Planning application no: 3/2013/0014

Proposal: Outline Planning Application for residential development, including details of the means of access to the land.

Location: Land adjacent to St. Paul's Church, Edisford Road, Clitheroe.

Proposed Site Layout

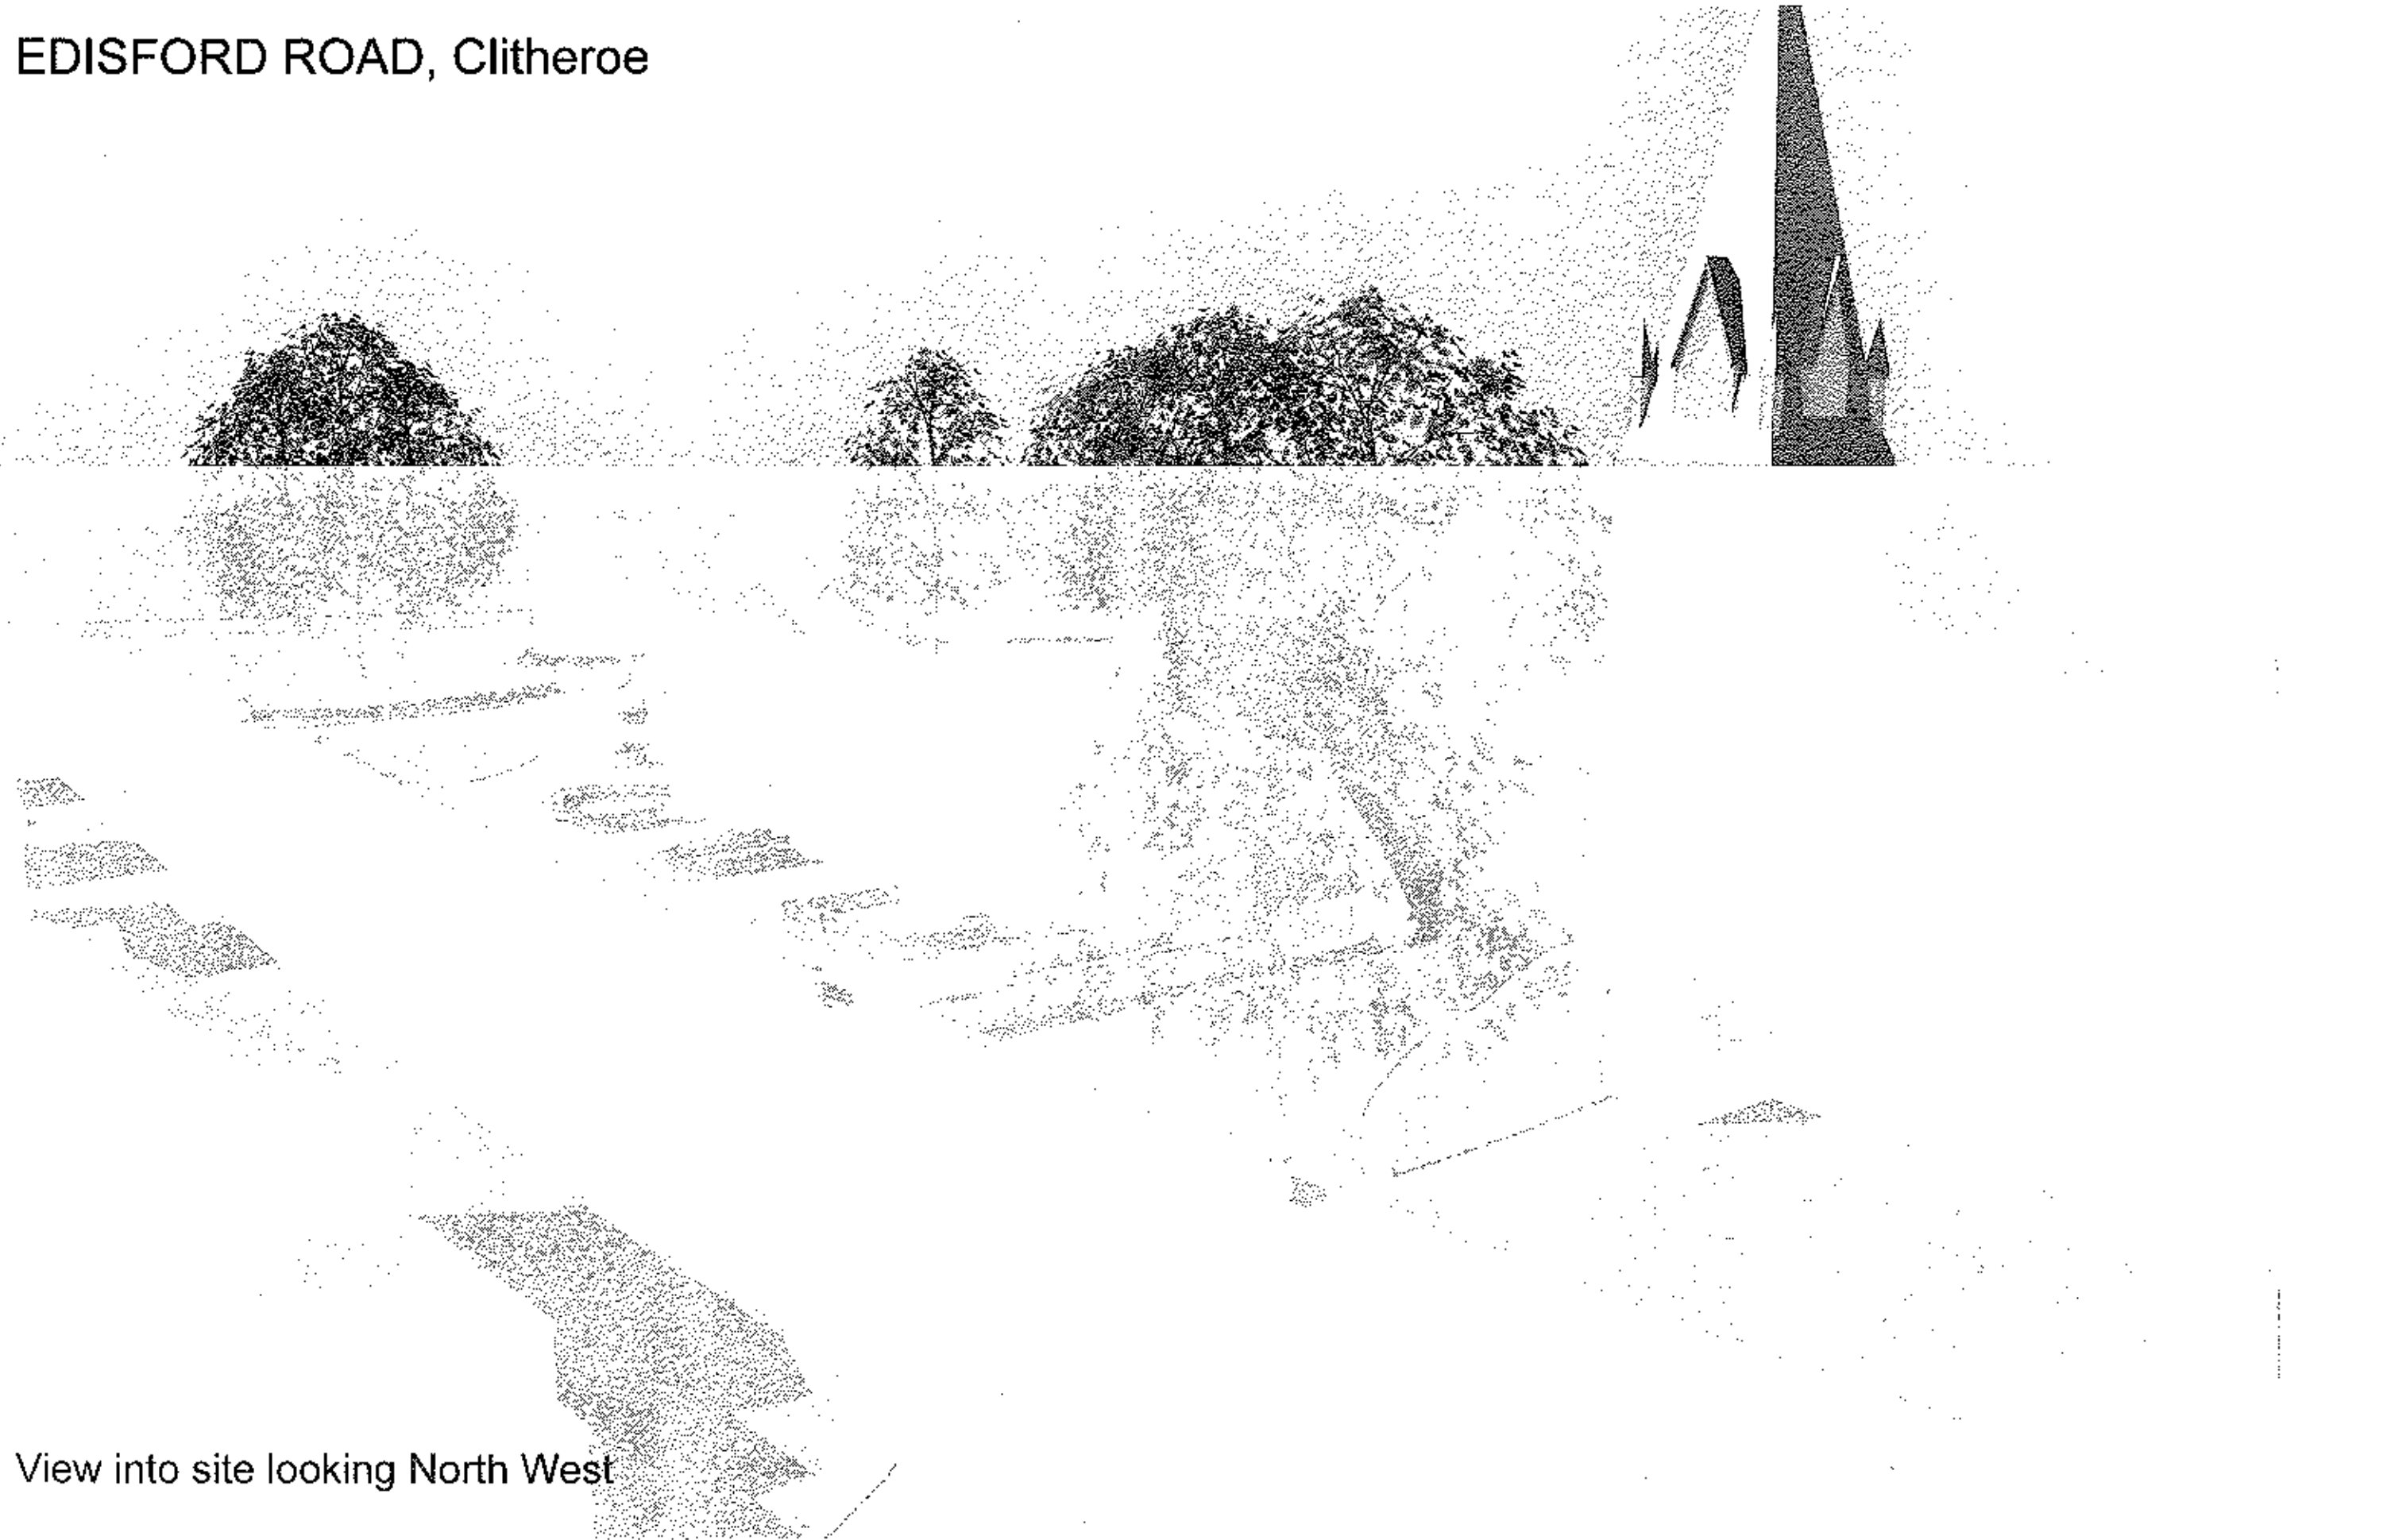
The proposed access onto Edisford Road is acceptable, but please note there is an alternative acceptable access from the site onto St. Paul's Terrace.

Visibility splays onto Edisford Road of 2.4m by 43 are required in each direction at the proposed access.

Pedestrian access should be provided through the existing gate in the Edisford Road frontage at the eastern end of the site.

I would ask that provision should be made for pedestrian access onto the claimed footpath so that if this is confirmed, the residents of this estate can use it. Please ask the developer to contribute up to £3000 for the improvement of the claimed footpath, under a section 106 agreement. If this footpath is not confirmed, then the funds would not be requested.

Pedestrian access onto St Paul's Terrace should also be provided, whether or not the footpath is confirmed.

Notwithstanding the submitted plans all garage doors shall be located at least 5.5m back from the highway boundary at all times and the garages and driveways thereafter kept clear for the parking of a private motor vehicle and cycle. Reason: to ensure satisfactory off street parking arrangements are preserved at all times.

The visibility splay to be the subject of this condition shall be that land in front of a line drawn from a point 2.4m measured along the centre line of the proposed estate road from the continuation of the nearer edge of the carriageway of Edisford Road to points measured 43m in each direction along the nearer edge of the carriageway of Edisford Road, from the centre line of the access, and shall be constructed and maintained at footway/verge level in accordance with a scheme to be agreed by the Local Planning Authority in conjunction with the Highway Authority. Reason: To ensure adequate visibility at the street junction or site access.
